Application for a non-material amendment following a grant of planning permission.
Town and Country Planning Act 1990

APPLICATION FOR A SMALL-SCALE CLEAR EXTENSION
TO THE SIDE-TO-BE-REMOVED OF THE DWELLING
FOLLOWING DEMOLITION OF THE EXISTING
GARAGE.

Please describe the non-material amendment(s) you are seeking to make:

23/444/ALT/P/01

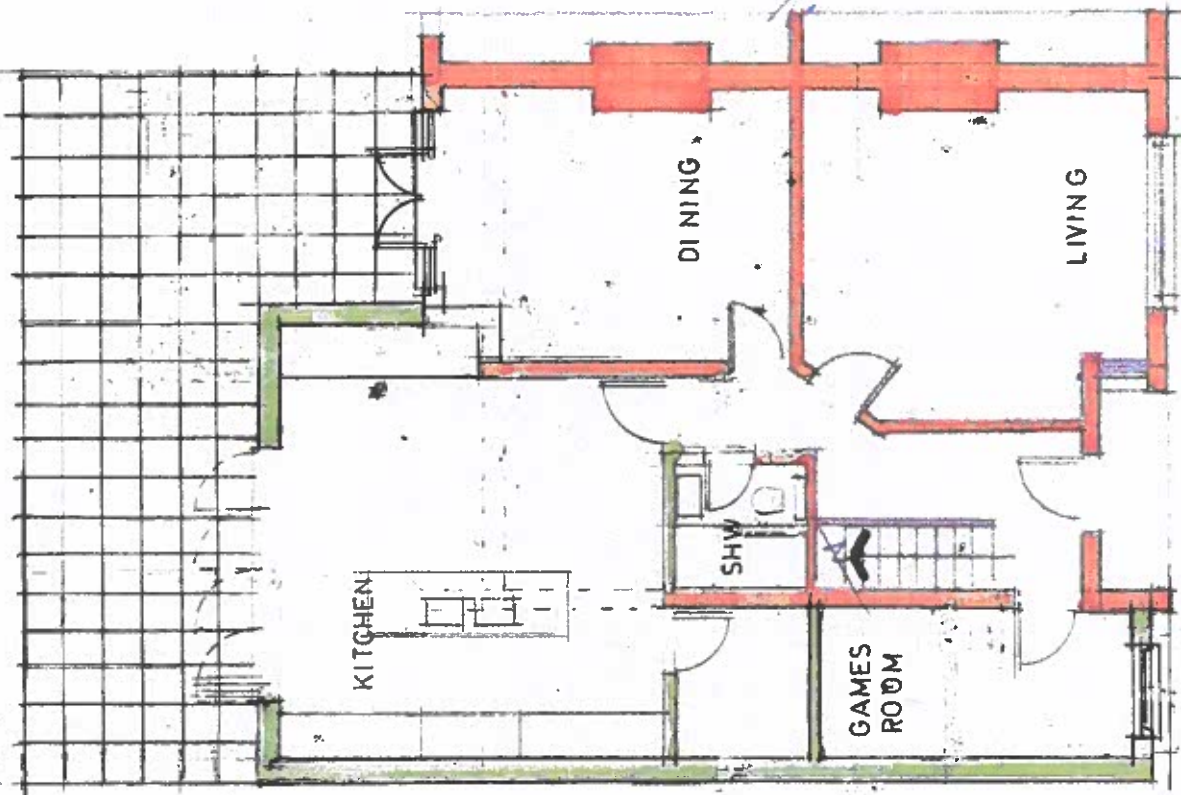
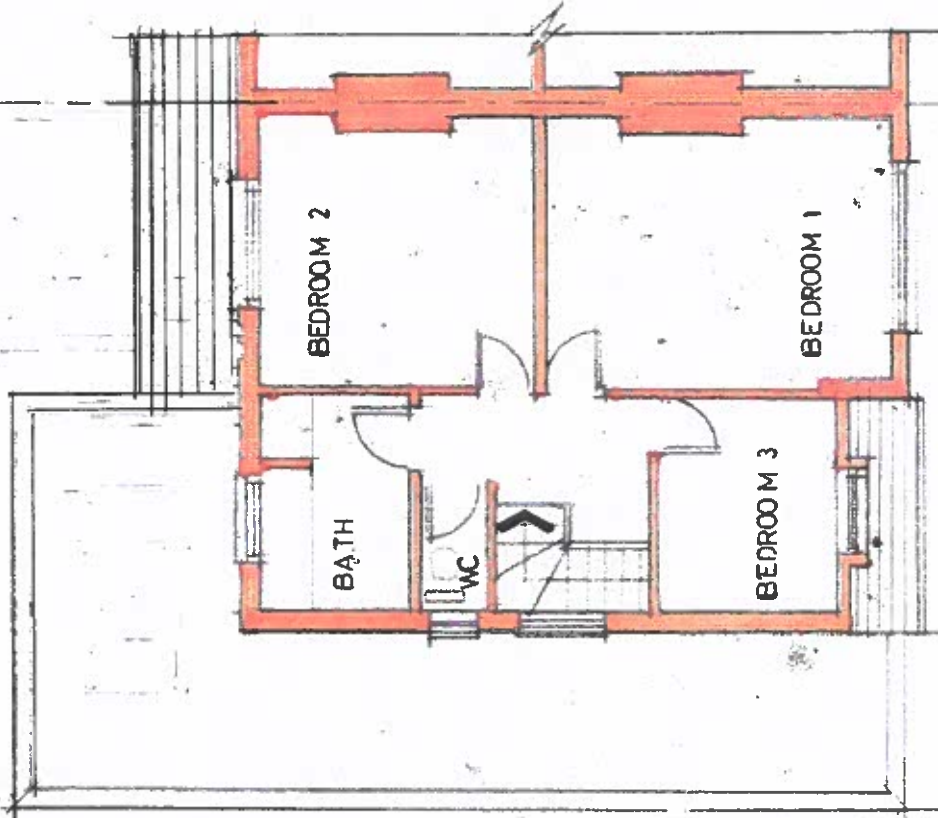
- omission of garage roof
- change of door to window front elevation
- include permit to work.
